# Appeal Decision

**Appeal Ref: APP/P5870/D/23/3324454**

**63 Hilldale Road, Cheam SM1 2JA**

- The appeal is made under section 78 of the Town and Country Planning Act 1990 against a refusal to grant planning permission.
  - The appeal is made by Mr Pirabakaran Thanabalasingam against the decision of the Council of the London Borough of Sutton.
  - The application Ref DM2023/00123, dated 25 January 2023, was refused by notice dated 28 March 2023.
  - The proposed development is for a first floor side extension.
-

Block Plan
1 : 500

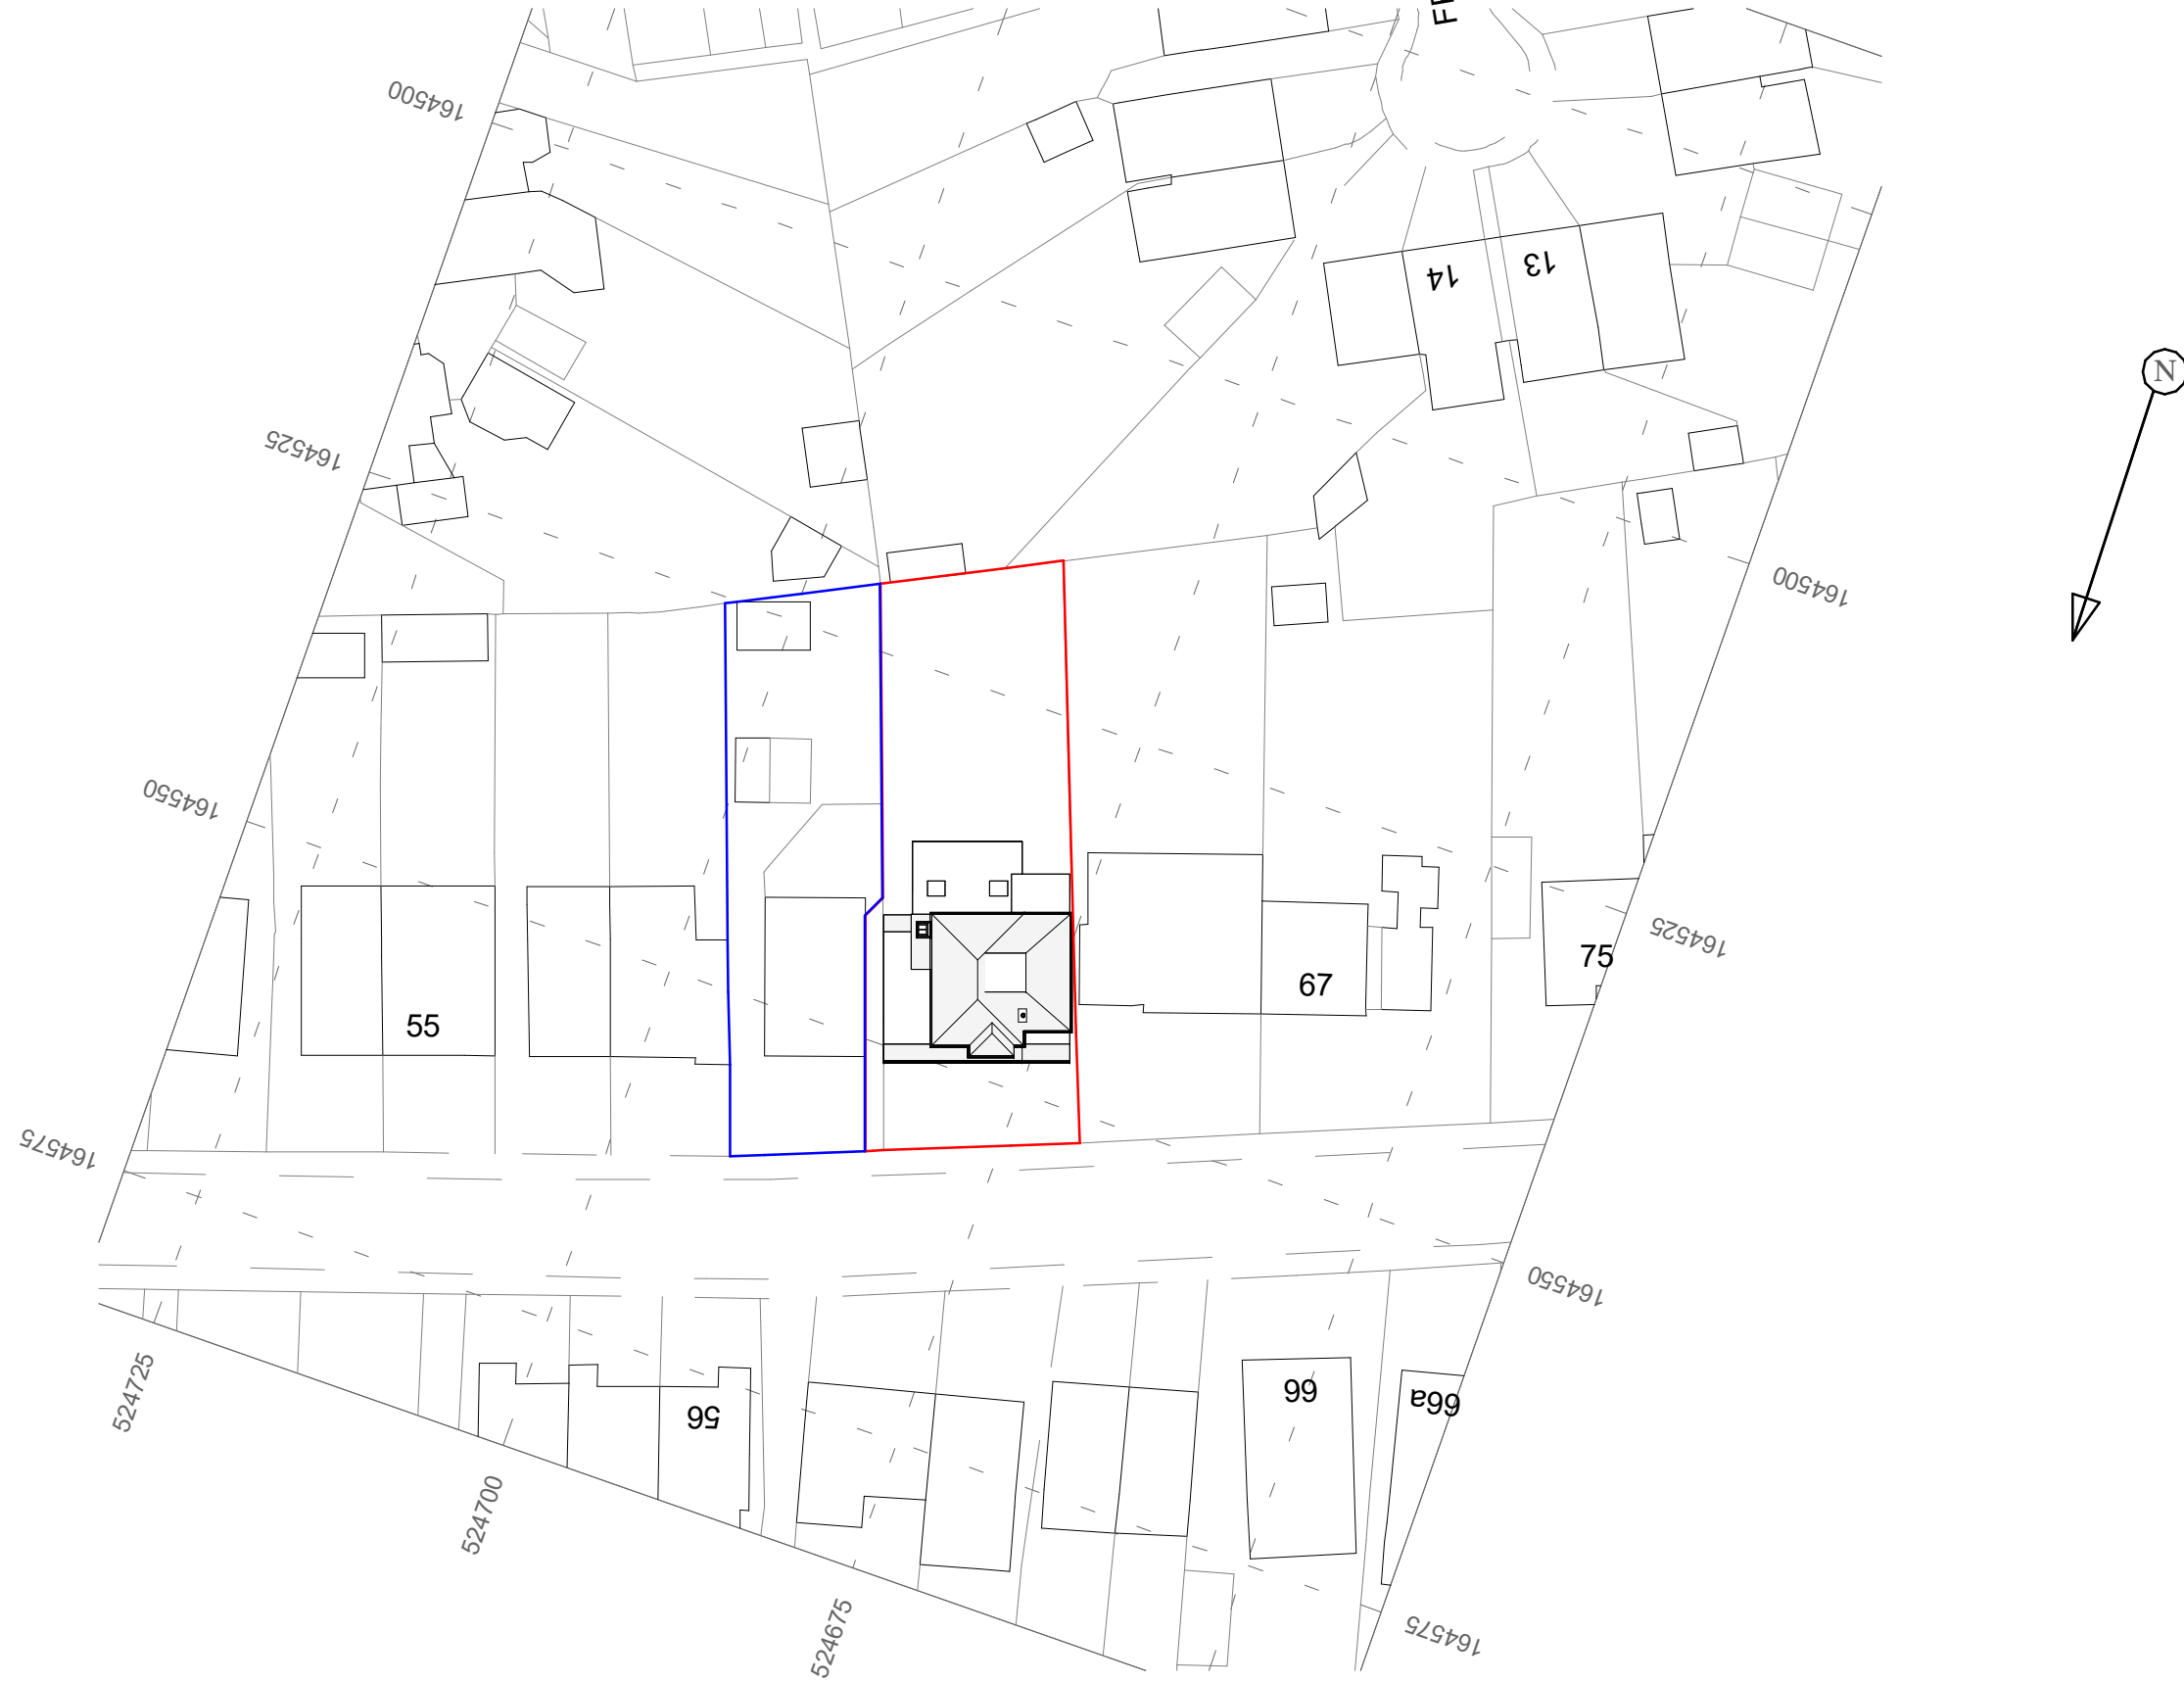
6. The resultant gap between the appeal property as extended at first floor level and nos. 61 and 61A Hilldale Road would be nearly 2.1 metres as shown on the proposed block plan. Based on the guidance in the SPD and having regard to my observations on site, this arrangement would avoid a terracing effect, reflecting the spacing of neighbouring properties elsewhere along the public highway, and would be harmonious within the context of the streetscene.

Proposed Front Elevation
1 : 100

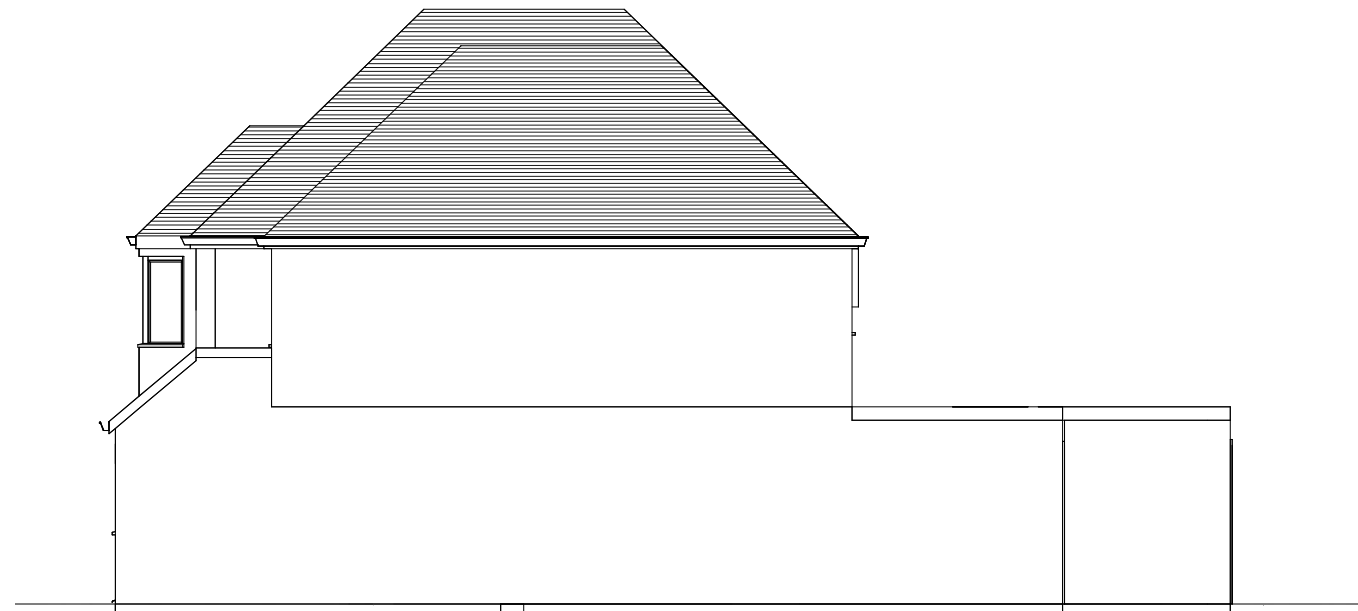
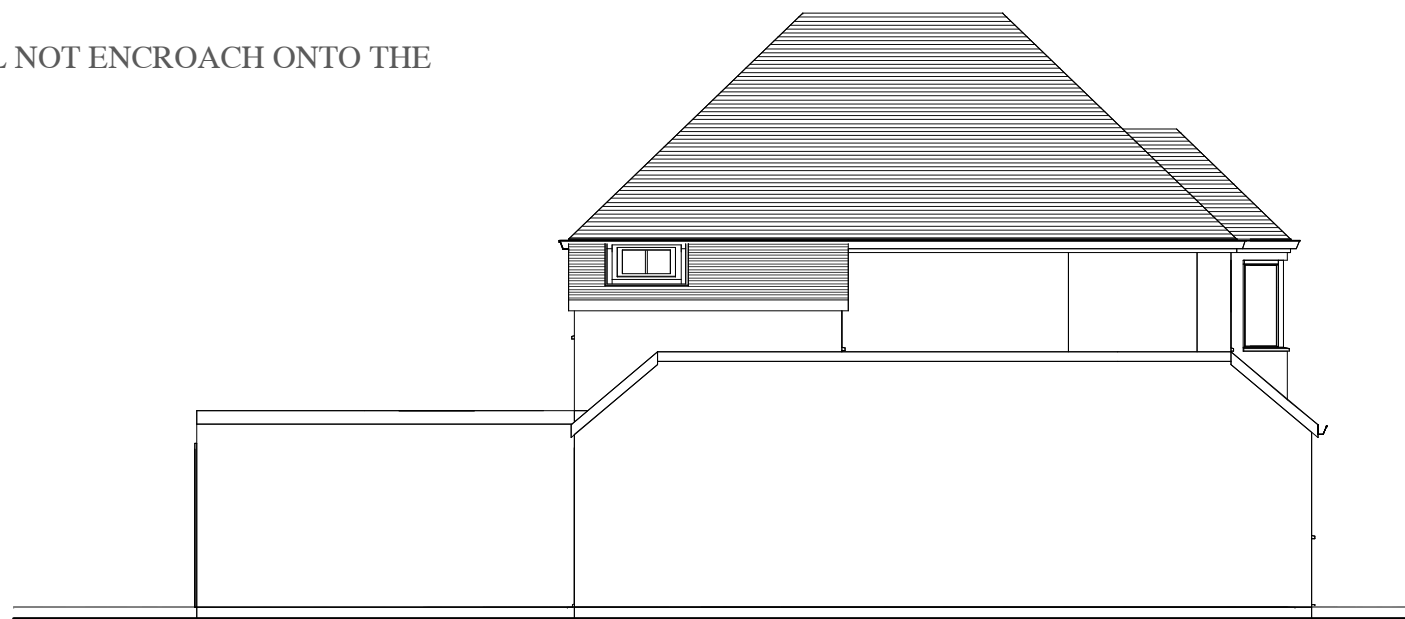
5. The elevation plans show that the extension would be set below the ridge line of the host building, and set back from the front elevation, thus creating a sense of subservience. The form, pitch and materials for the roof would broadly match the existing dwelling. Overall, in my view the scheme would visually connect with the general appearance of the host dwelling, without dominating it, and respond to the original design characteristics.
